October 1, 2024 Ref. No. CO947.03

Grading Letter to supplement the Geotechnical Investigation Report Wateridge Village, Block 6, Ottawa, Ontario

"Grading Plan", Sheet Number C-200, prepared by Arcadis, dated September 25, 2024.

**SHEET NUMBER**  
**C-200**  
**ISSUE**  
**6**

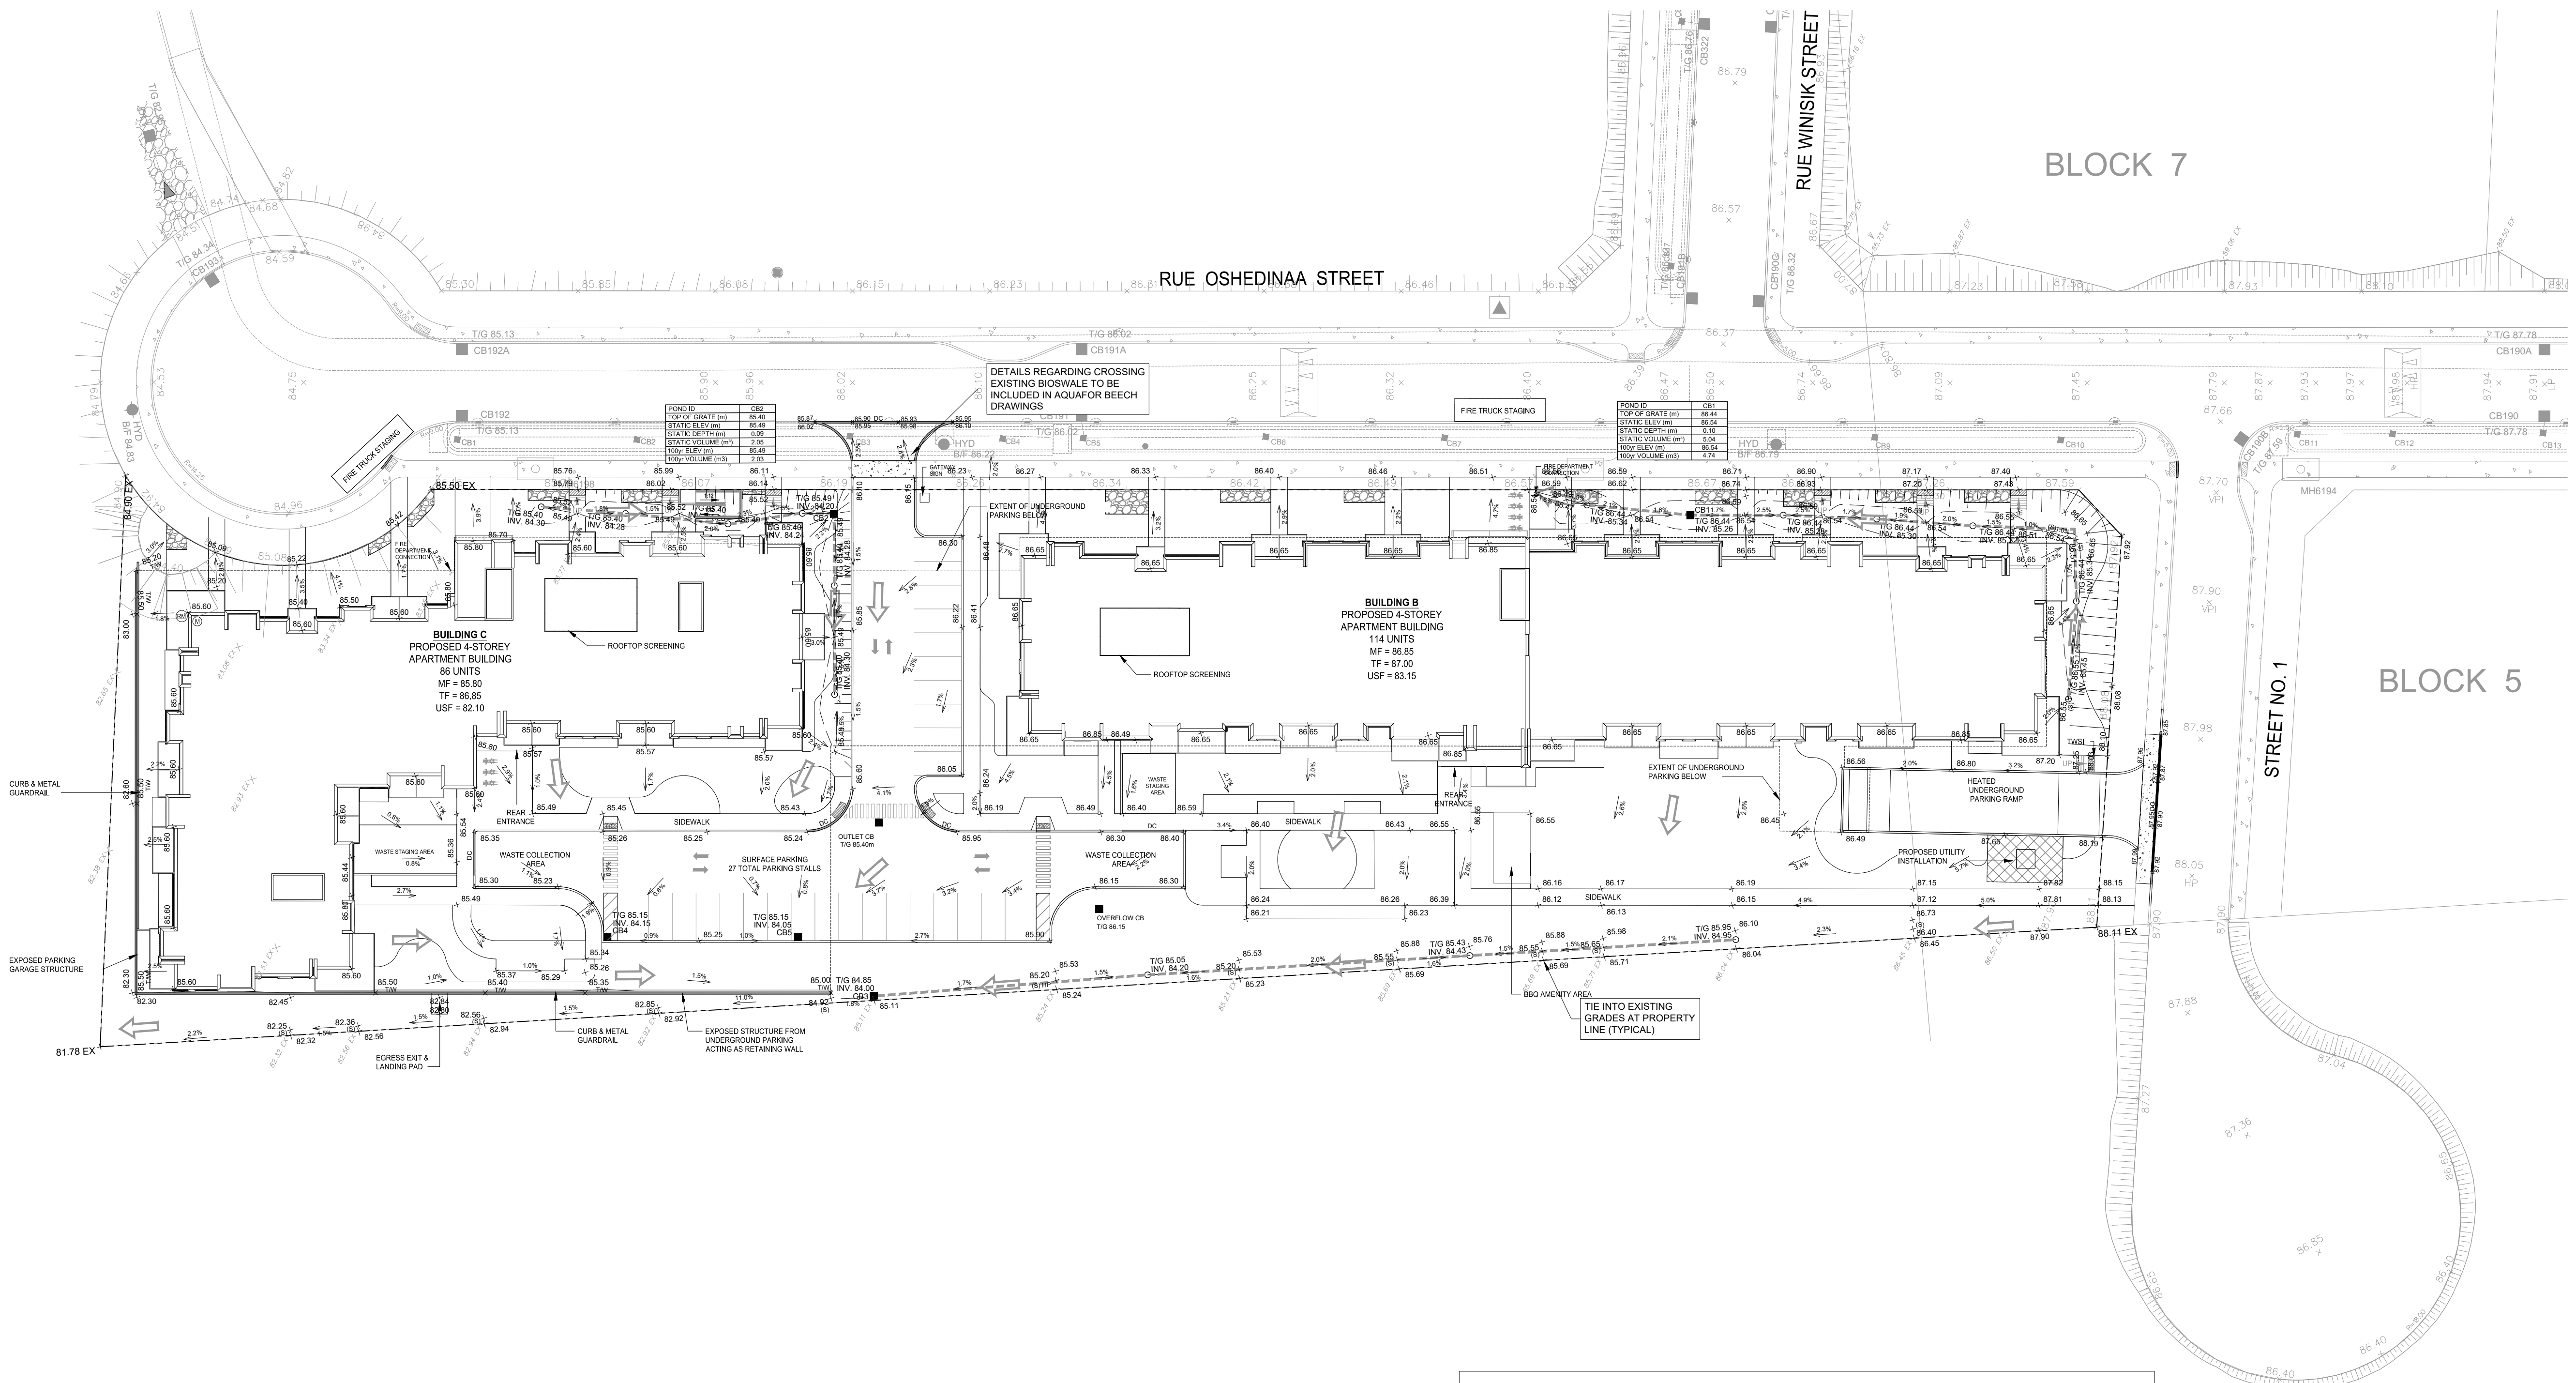
According to the architectural drawings prepared by NORR Architects & Engineers Limited, dated September 25, 2024, provided to Terrapex by the Client, it is understood that the underground parking will cover the majority of the site, except for the south of Building C, and southwest corner of Building B. The finished grade in areas which are outside the footprint of the underground parking varies from 85.1 masl to 88.15 masl. According to the elevations surveyed at the borehole locations, the existing topographic elevation within the above area varies from 85.9 masl to 87.4 masl. As such, the proposed grade change is -0.8 m (cut) to 0.7 m (fill).

Based on the findings of the geotechnical investigation at the locations of BH6-4, BH6-6 and BH6-7, the soil stratigraphy outside the footprint of the underground parking consists of approximately 1.5 m to 2.5 m of fill material, overlying bedrock. The fill material was observed to be soft to firm silty clay in BH6-4, loose sandy silt in BH6-6, and locally very dense sand and gravel at the location of BH-7. Any soft to firm cohesive fill materials and loose non-cohesive fill materials shall be sub-excavated and replaced with engineered fill, constructed with select clean fill materials,

The proposed grading has a maximum steepness of 3H:1V, which is satisfactory and will provide a factor of safety of 1.5 against slip failure.

under the supervision of the Geotechnical Engineer. For further recommendations regarding engineered fill placement and pavement design, reference should be made to the Geotechnical Investigation Report.
